**KIRKLEES METROPOLITAN COUNCIL
INVESTMENT & REGENERATION SERVICE**

Reference No:	2024/62/93143/W
Site Address:	5, Coach House, Manchester Road, Marsden, Huddersfield, HD7 6NL
Description:	Change of use of land to extend domestic garden and erection of single storey extension and detached garage
Recommending Officer:	Molly Storer

DECISION – CONDITIONAL FULL PERMISSION

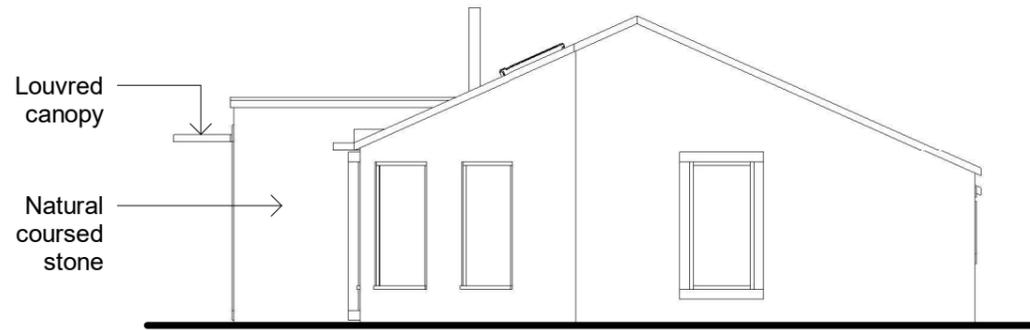
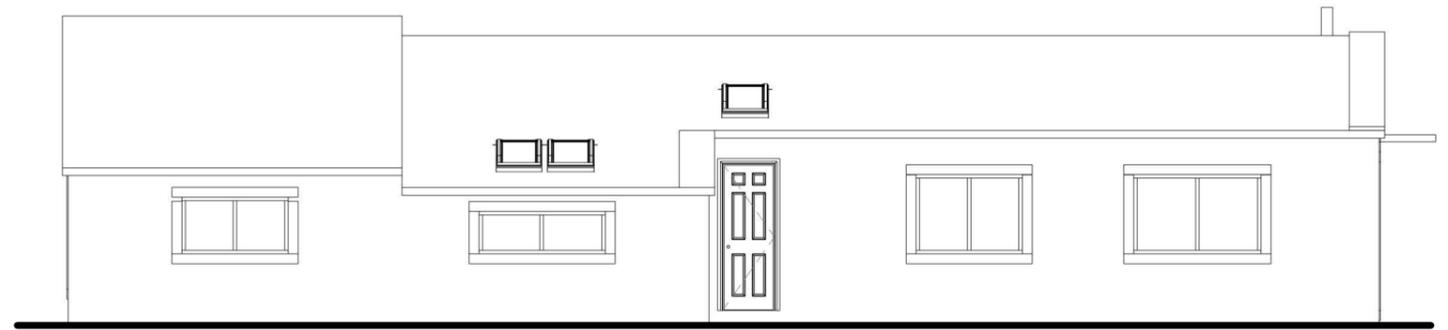
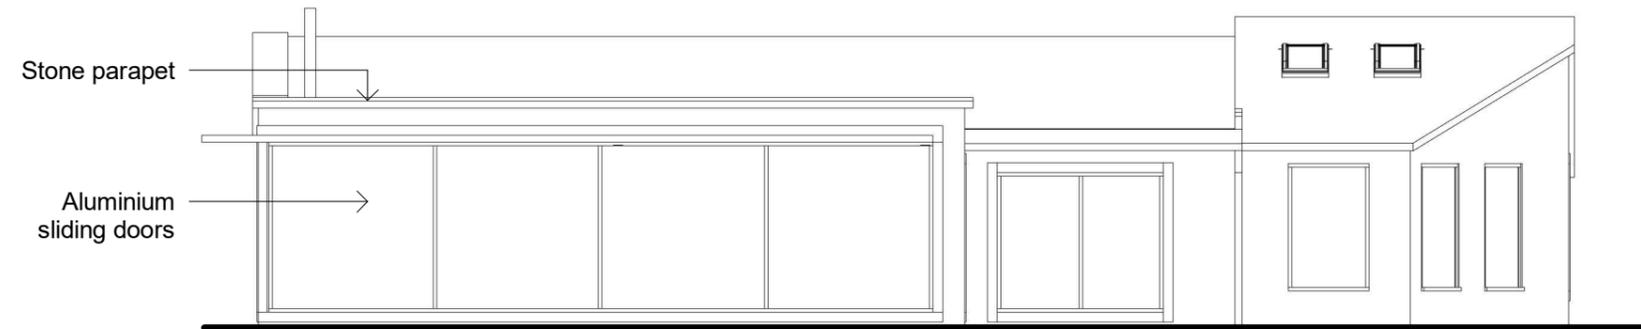
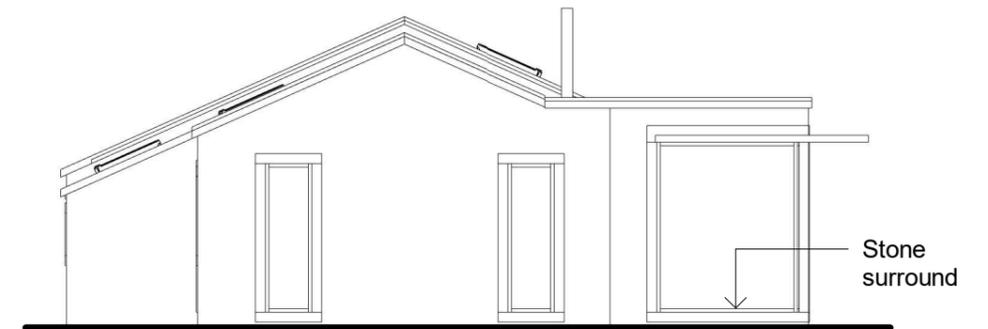
In addition, a single storey extension is proposed to the rear of the dwelling. This is proposed to have a projection of 2.6m, a width of 10m and a height of 3.2m. The extension is proposed to have a flat roof, which would sit just above the eaves of the rear elevation of the dwelling. The walls of the extension are proposed to be constructed from natural stone to match the existing dwelling.

The revised design from the 2021 application now increases the amount of glazing along the walls to create a slightly more contemporary look and it omits the skylights from the design.

Whilst the eaves of the proposed extension slightly exceed the height of those on the original dwelling and because of this the proposed extension does not strictly constitute permitted development, this is considered to be a minor

3. The external walls of the rear extension hereby approved shall in all respects match those used in the construction of the existing building.

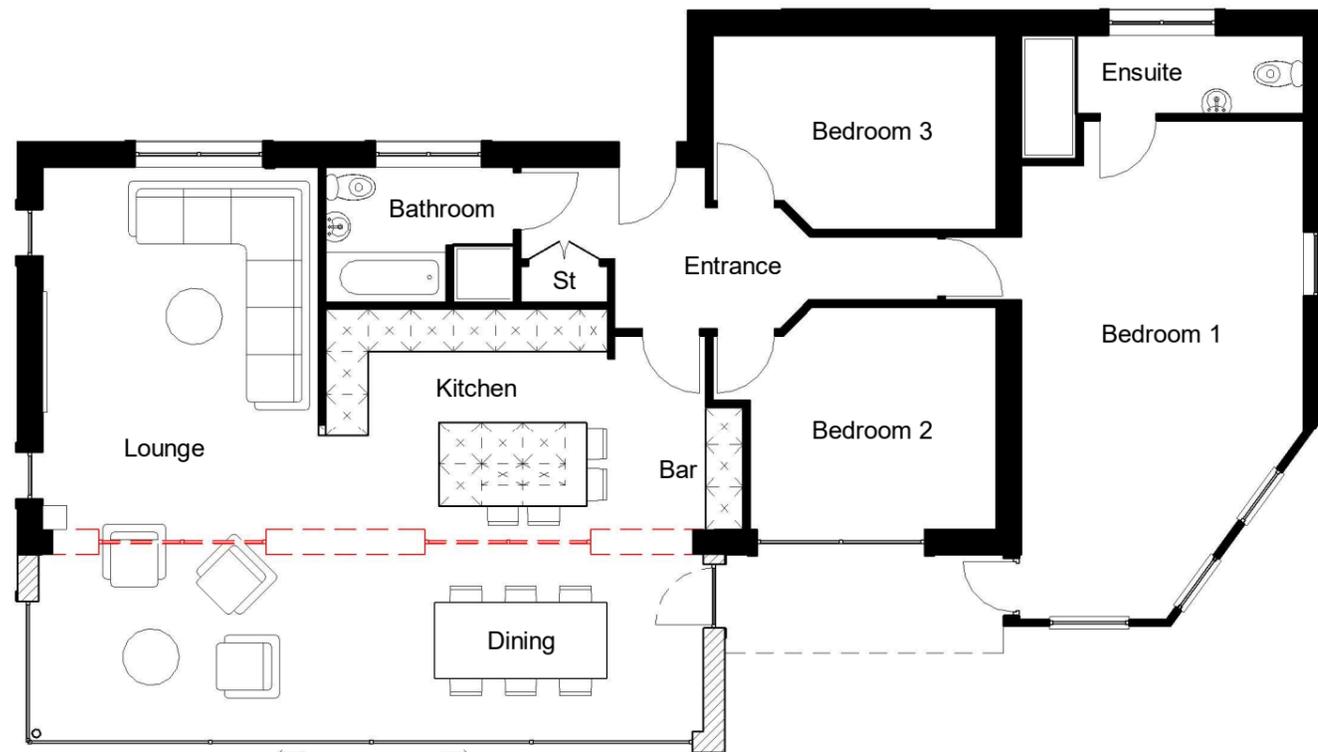
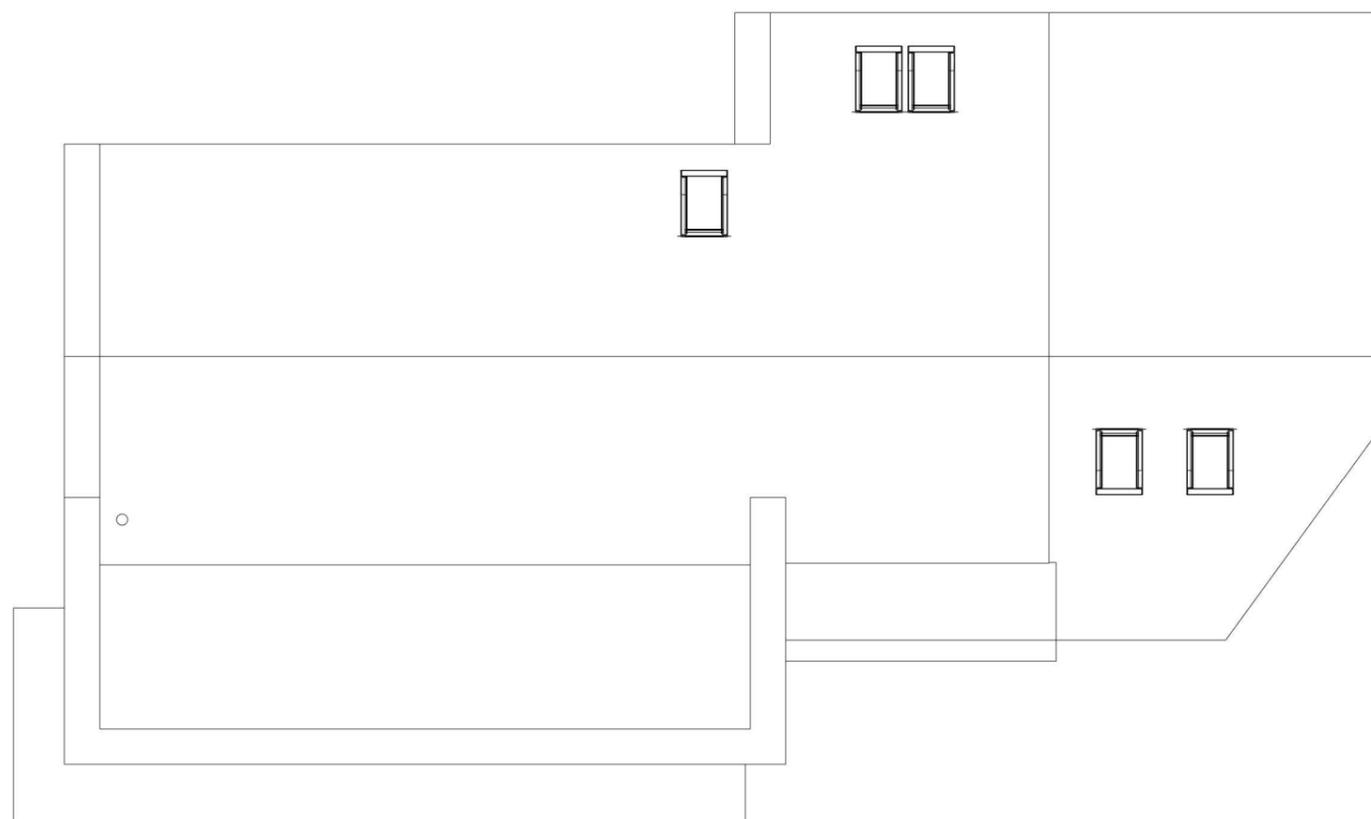
The proposed rear single storey extension adds 28m² and in combination with an extension to the dwelling approved in 2009 (2009/92056) would result in a ~63m² addition to the ~93m² original dwelling (an increase of 67%). Whilst it is acknowledged that this is a large increase it is also noted that there is no formal definition of disproportionate additions and each application must be assessed on its own merits. Previous case law has demonstrated that the assessment of disproportionate additions cannot be made purely in a mathematical way by reference to size when measured in floor space, volume or mass, but that appearance and visual impact are an important part of a proper evaluation. In this instance weight is given to the effect of the proposal on the openness of the Green Belt and on the character and appearance of the area.

Given that the land to the rear of the dwelling is now likely to be lawfully domestic garden (as discussed above), it is considered that the single storey extension would not cause harm to the openness of the green belt or conflict with the purposes of including land within the green belt. Given the above, that it would be relatively well screened from Manchester Road and that the walls are proposed to be constructed from materials to match the existing dwelling, it is considered that the extension would not cause detrimental harm to the visual amenities of the locality.

Proposed Site Plan

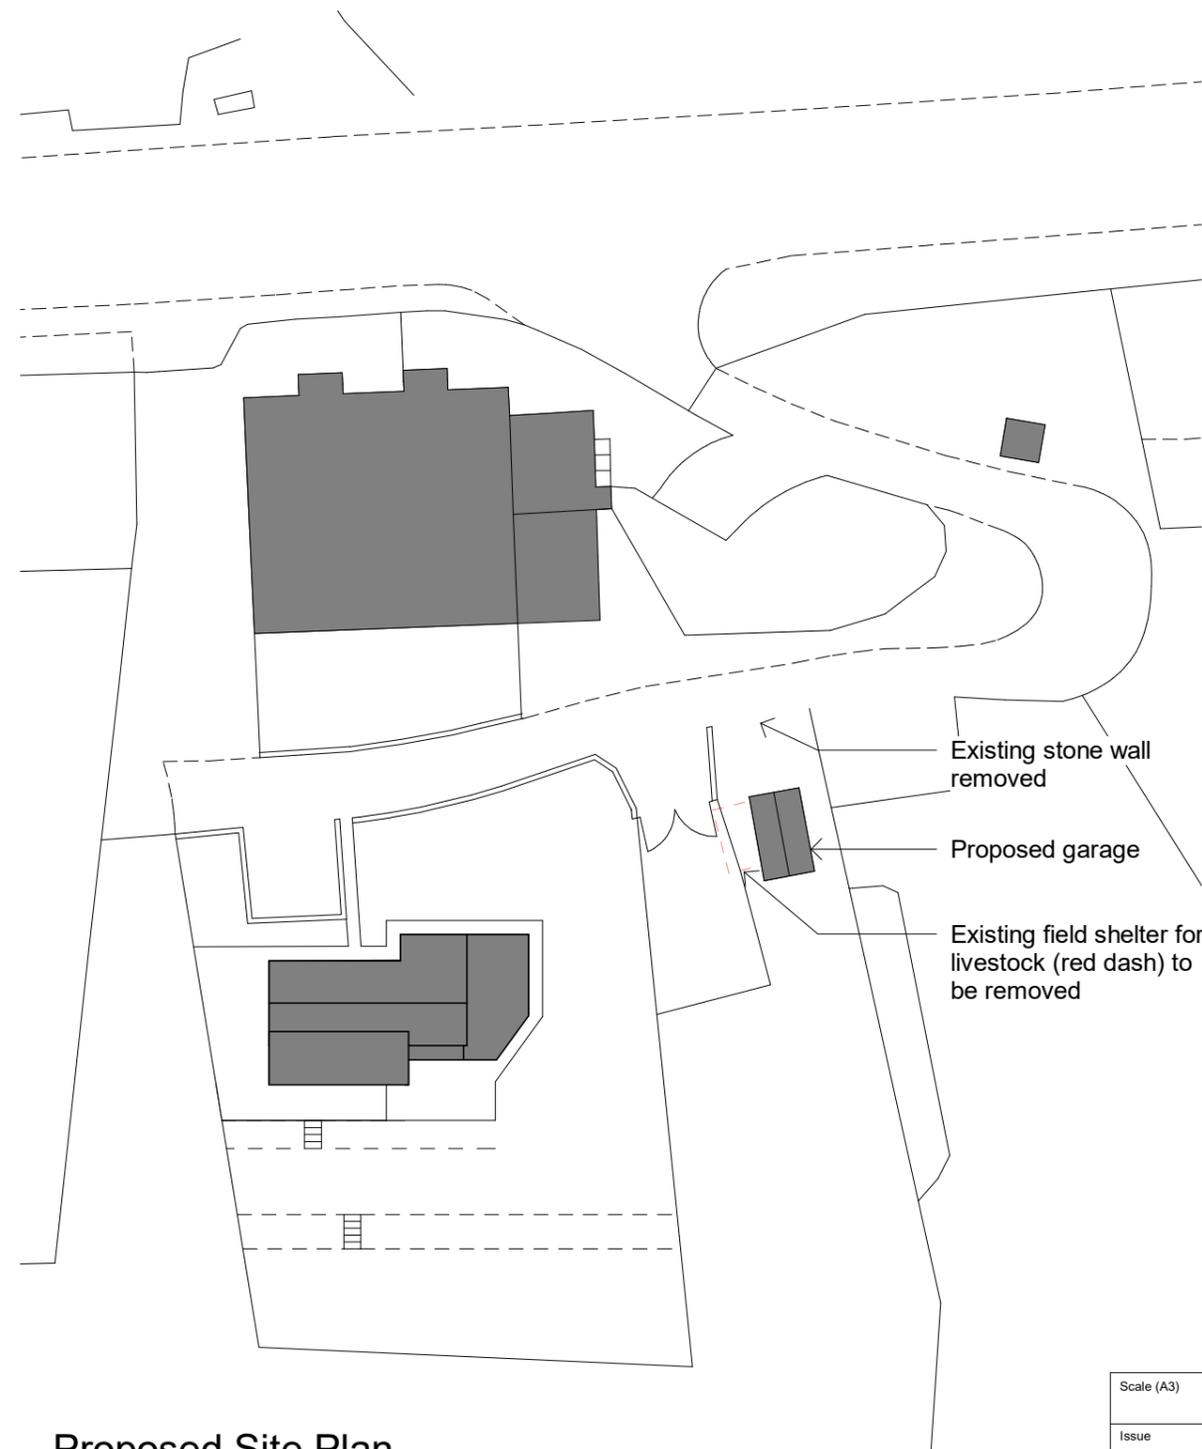
This proposed building would replace an existing single storey outbuilding with another single storey outbuilding outside of the residential curtilage of the dwelling, and whilst slightly larger it is not considered to be materially larger in scale than the building it is proposed to replace. The outbuilding does not benefit from permission, but from using satellite imagery, Officers are confident that it has existed on site for over 4 years so is likely to be lawful. However, it appears that this building has been used for agricultural purposes, whilst the garage is for domestic purposes therefore the proposed garage is considered to constitute inappropriate development in the Green Belt.

As the garage would be on a similar footprint to the existing building and would not be materially larger than it, it is considered that it would not cause greater harm to the openness of the green belt or conflict with the purposes of including land within Green Belts. Given the above, it is also considered that the garage would not cause detrimental harm to the visual amenities of the locality.

The garage will be well set back and screened from Manchester Road behind an existing access road and retaining walls. It is also set on a much lower ground level than Manchester Road and will be small in scale replacing an existing outbuilding on a similar footprint. Therefore, the outbuilding will not appear to compete with prominence with the existing dwelling or the surrounding development. The location of the proposed outbuilding is therefore considered acceptable from a visual amenity perspective.

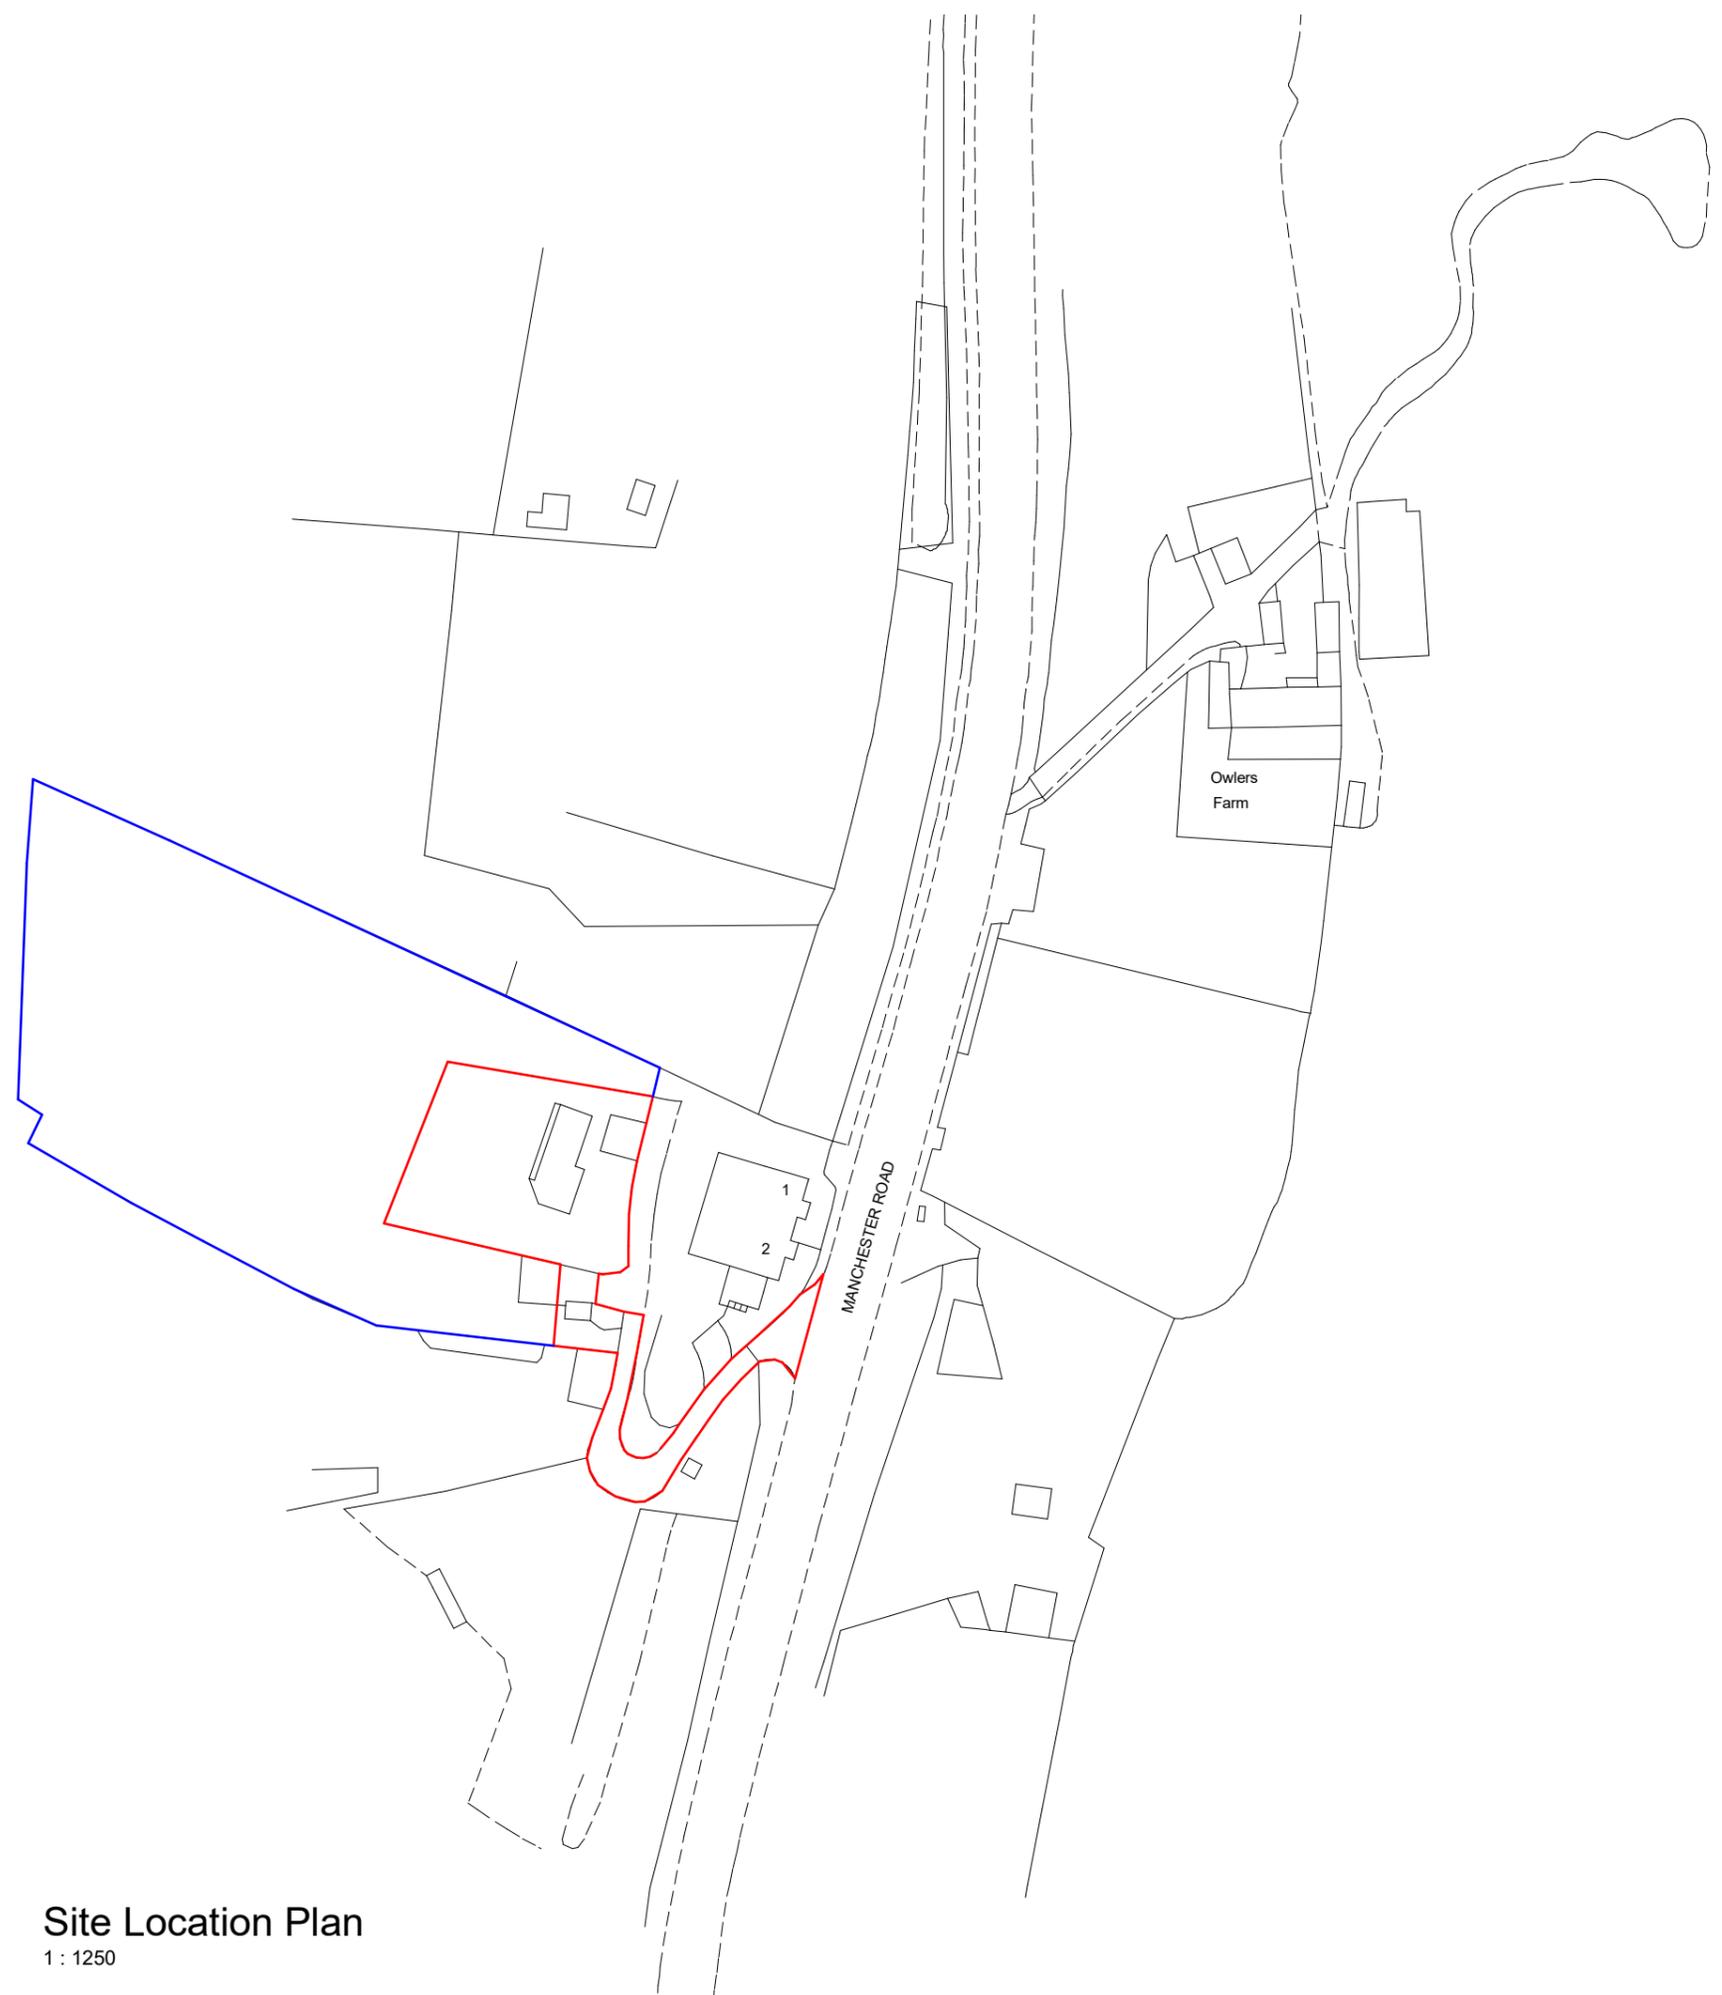
Given the isolated and open nature of the site, it is considered necessary to remove permitted development rights for outbuildings within this established curtilage of the site, as well as any new fencing (the current post and rail fencing is considered appropriate given the circumstances of this application).

4. Notwithstanding the provisions of the Town and Country Planning (General Permitted Development) (England) Order 2015 as amended (or any Order revoking or re-enacting that Order) no development included within Classes A, AA, B, D or E of Part 1 of Schedule 2 to that Order shall be carried out without the prior written consent of the Local Planning Authority within the site outlined in red on the hereby approved location plan Dwg No.PL01.

5. Notwithstanding the provisions of the Town and Country Planning (General Permitted Development) (England) Order 2015 as amended (or any Order revoking or re-enacting that Order) no development included within Class A of Part 2 of Schedule 2 to that Order (means of enclosure) shall be carried out without the prior written consent of the Local Planning Authority within the site outlined in red on the hereby approved location plan Dwh No.PL01.
